221254-PUNCH-PL-JOK-ACP-LCCC-001

Re: Case Number: ABP-322242-25

Request for Further Information for Proposed Works at Bruree Bridge, Co. Limerick

TYPICAL PARAPET WALL SECTION SCALE 1:10

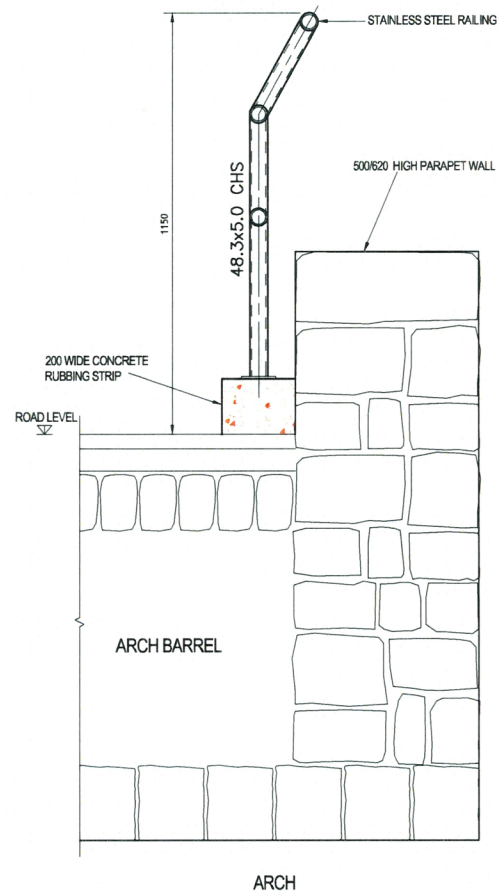
1. Detailed justification for the inclusion of the proposed railings, and their height and design, having regard to the visual and architectural impact on the protected structure and the provisions of the Architectural Heritage Protection Guidelines for Planning Authorities published by the Department of the Arts, Heritage and the Gaeltacht

The existing parapet walls are 500-620mm high and offer insufficient containment for pedestrians accessing the bridge and stainless-steel railings are proposed to address this concern. The railing containment shall be a minimum of 1100mm to Part K of the Building Regulations & BS 6180; with reference to 7.15 of the Architectural Heritage Protection Guidelines, there is a requirement to secure the health & safety of people as defined in the Building Regulations.

- Minimum effect on authenticity (fabric) - A contemporary stainless-steel barrier is proposed to make a clear distinction between the original bridge structure.
- Minimum Intervention - The railing will not impinge on the original structure as it will be readily defined by the difference between the original masonry and new steel material and not adversely interfere with the existing structure.
- Reversibility - The new stainless railing can be removed, allowing the bridge to return to its original state if required.
- Honesty of Intervention - The new railing is required as an additional safety measure to the bridge but does not try to imitate the original structure, keeping a clear distinction between old & new.
